Pikes Peak Regional Building  
Department

Enumerations has the following comments:

1/13/2025 10:16:59 AM

SITE PLAN

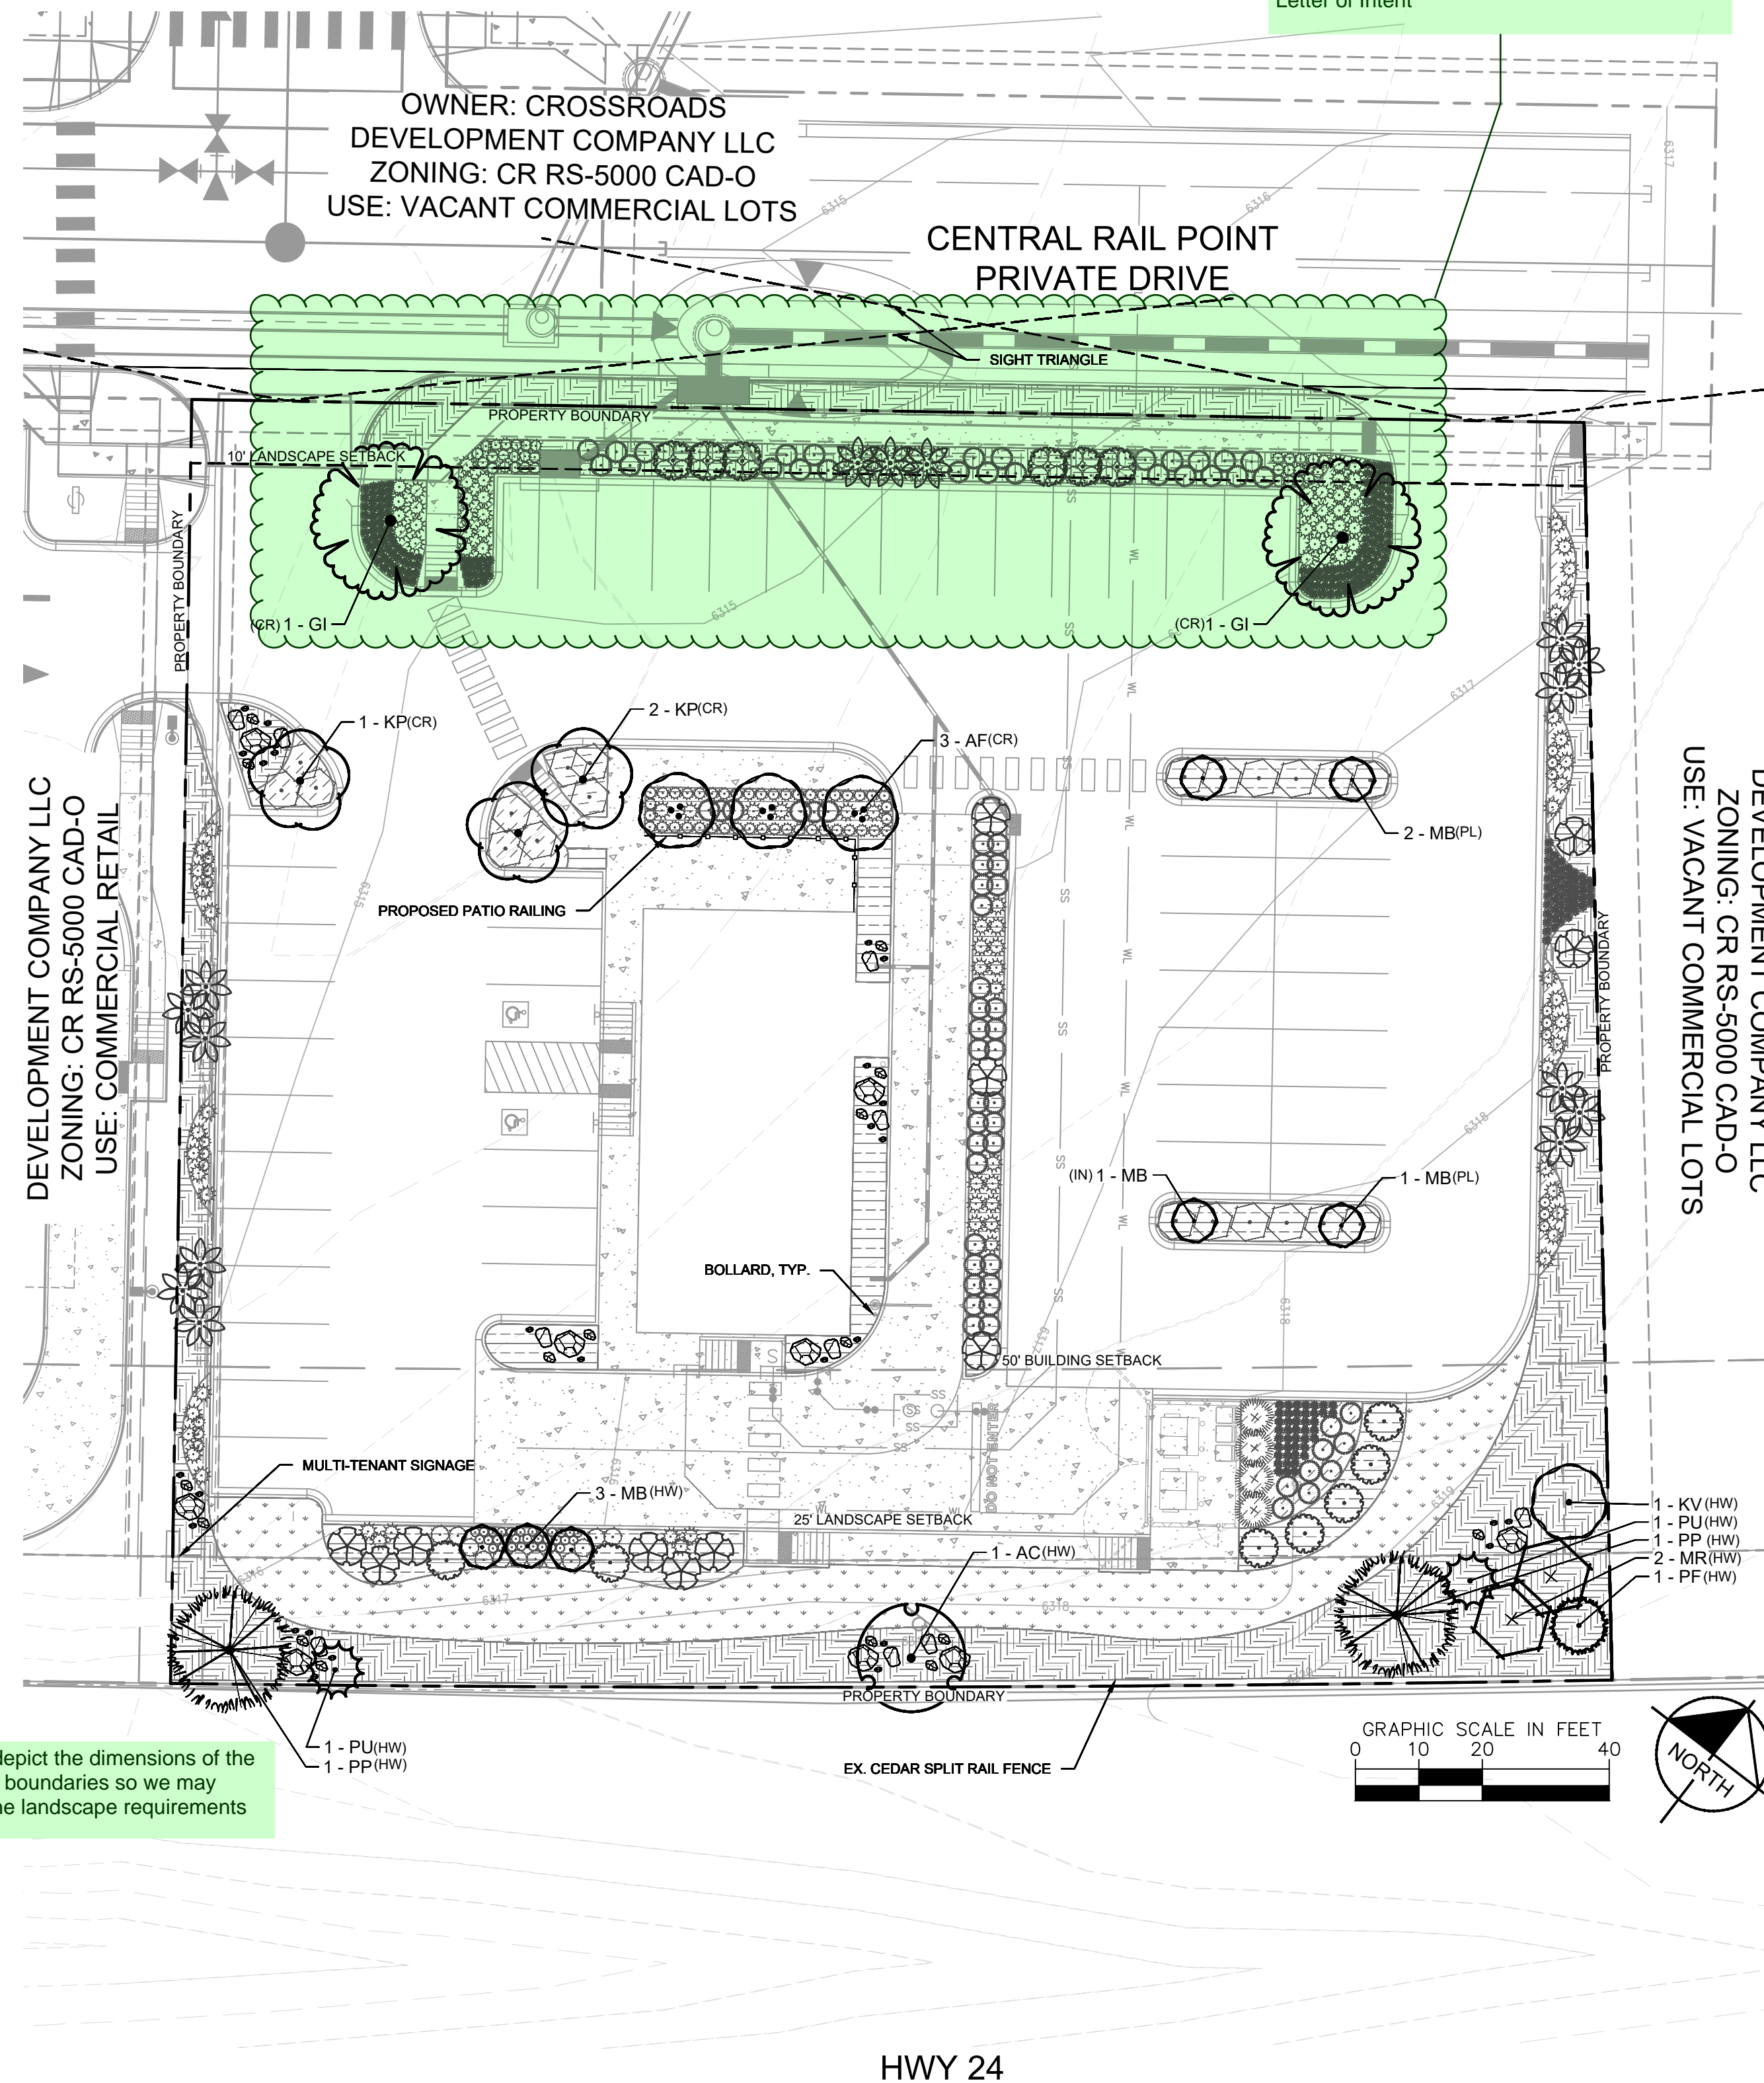
1. The addresses assigned to current Tract C Crossroads Mixed Use Filing No. 2 may change as part of the plat for Filing 3. Prior to submitting building plans for review/permit, the applicant needs to verify the address to be used once the addressing plan for Filing 3 has been created.
2. The street name of Central Rail Point is shown as Central Rail Way on the site plan. Update the plan to show the street name correctly.
